**Summary of the Written Submission  
Of the  
Royal Society for the Protection of Birds  
and Suffolk Wildlife Trust**

**Submitted for Deadline 2  
2 June 2021**

**Application by NNB Generation Company (SZC) Limited for an Order  
Granting Development Consent for  
The Sizewell C Project**

**Planning Inspectorate Ref: EN010012  
RSPB Registration Identification Ref: 20026628  
Suffolk Wildlife Trust Registration Identification Ref: 20026359**

SECTION B - B
SCALE 1:200

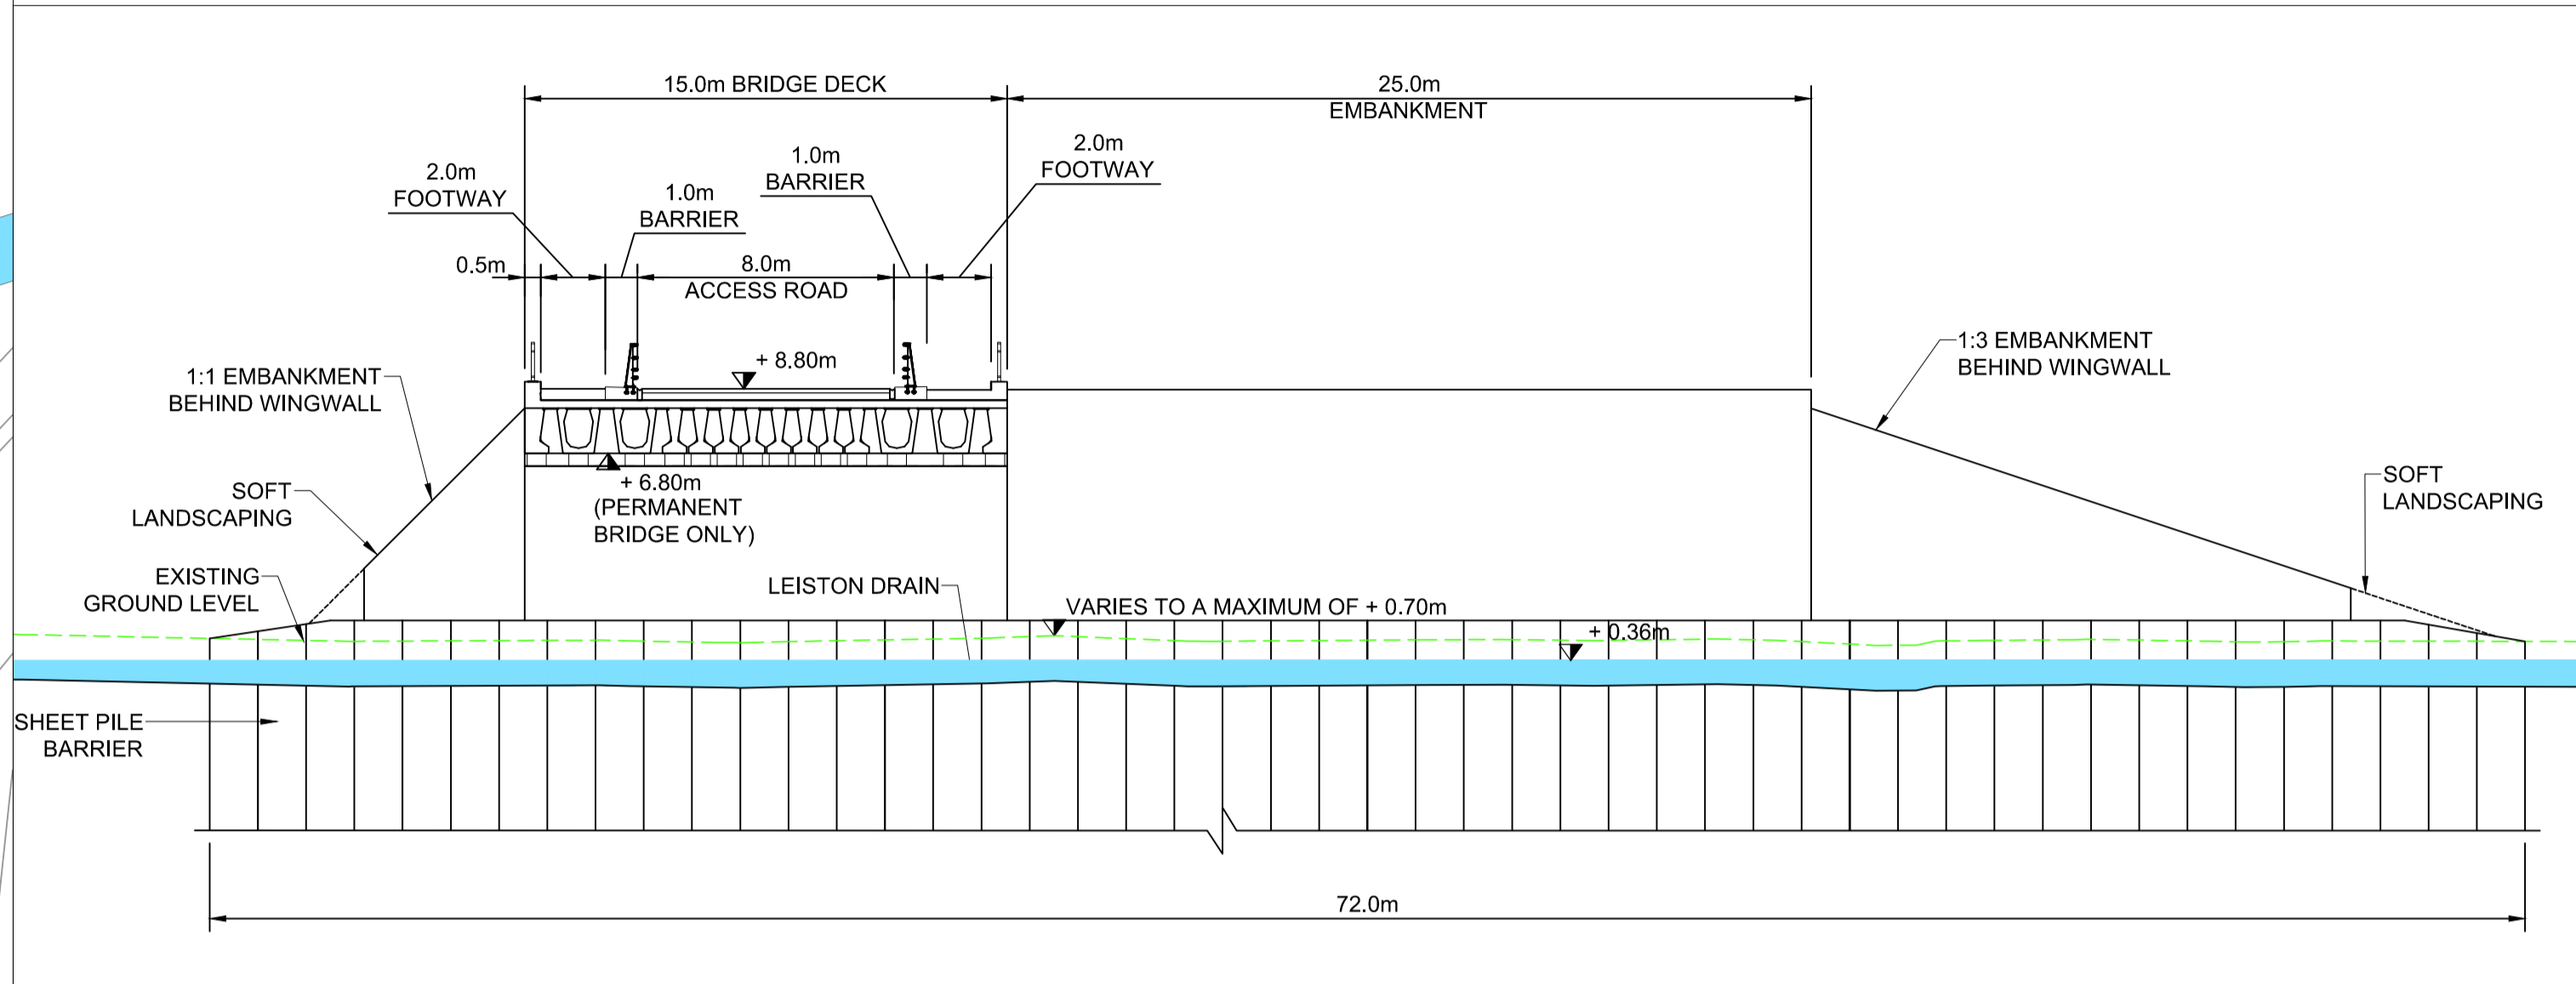
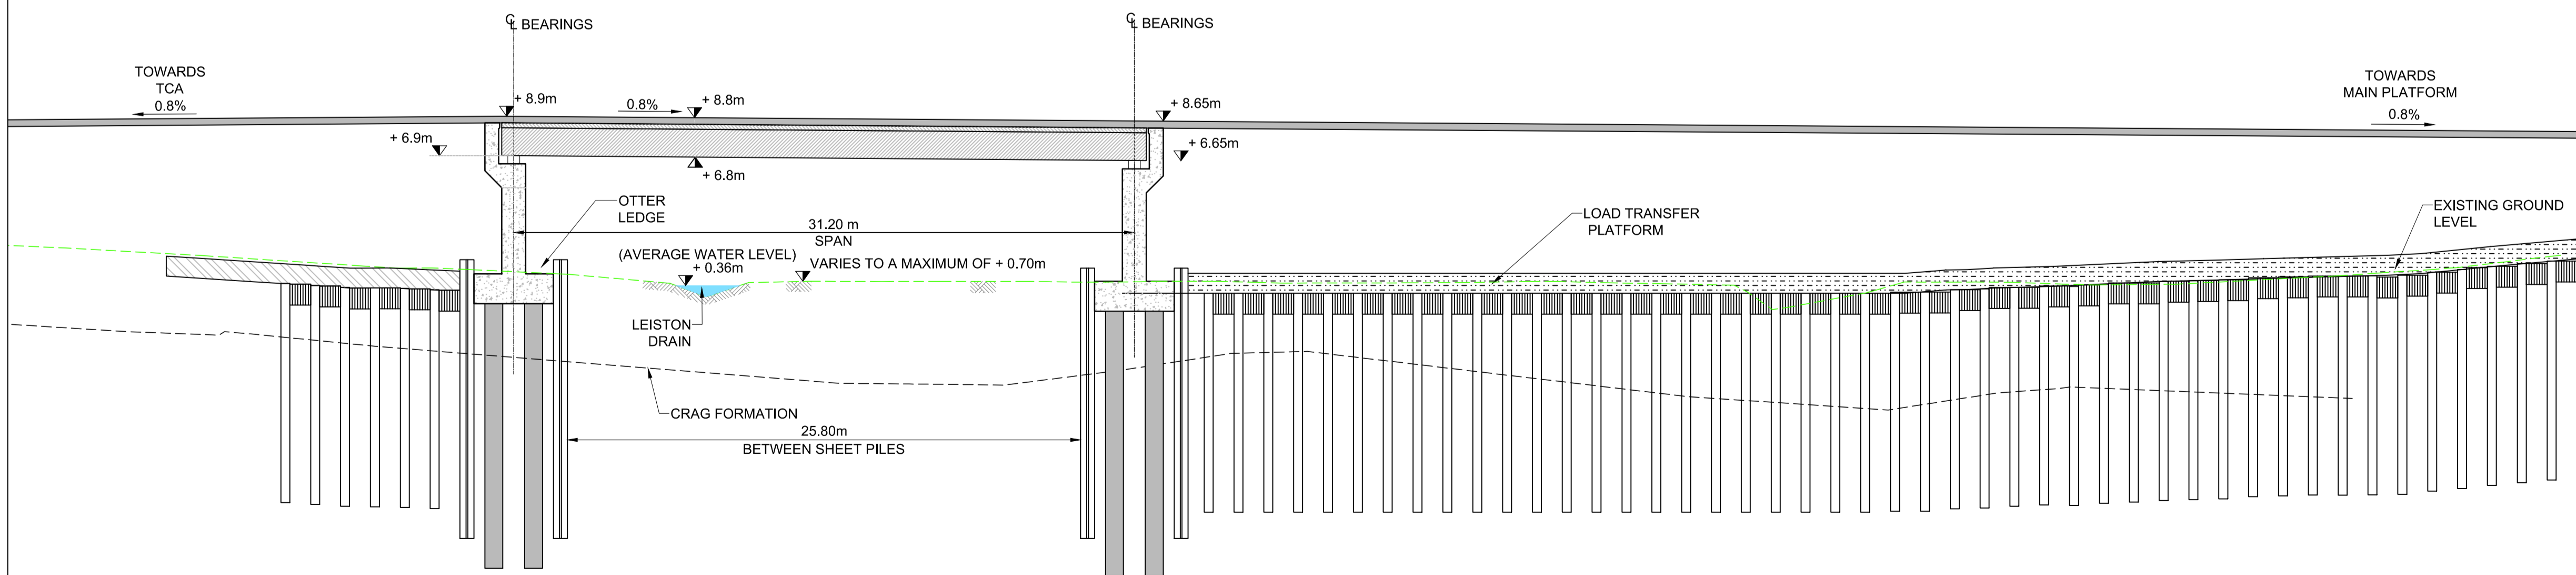
In addition, we are unconvinced about the Applicant's justification for the choice of an embankment and culvert (a single span 'bridge') rather than a triple span bridge to cross Sizewell Marshes SSSI, despite the higher land take from the SSSI. We are concerned that the loss of SSSI via the embankment/culvert option will lead to a much larger loss than the triple span bridge option, and this has not been adequately nor clearly justified. We consider the Applicant should assess and compare the impact of all four options for the SSSI crossing and provide sufficient evidence for Natural England to advise the Examination on any effects on the special interest of the SSSI. Also, a detailed design for the SSSI crossing has not been submitted to the Examination.
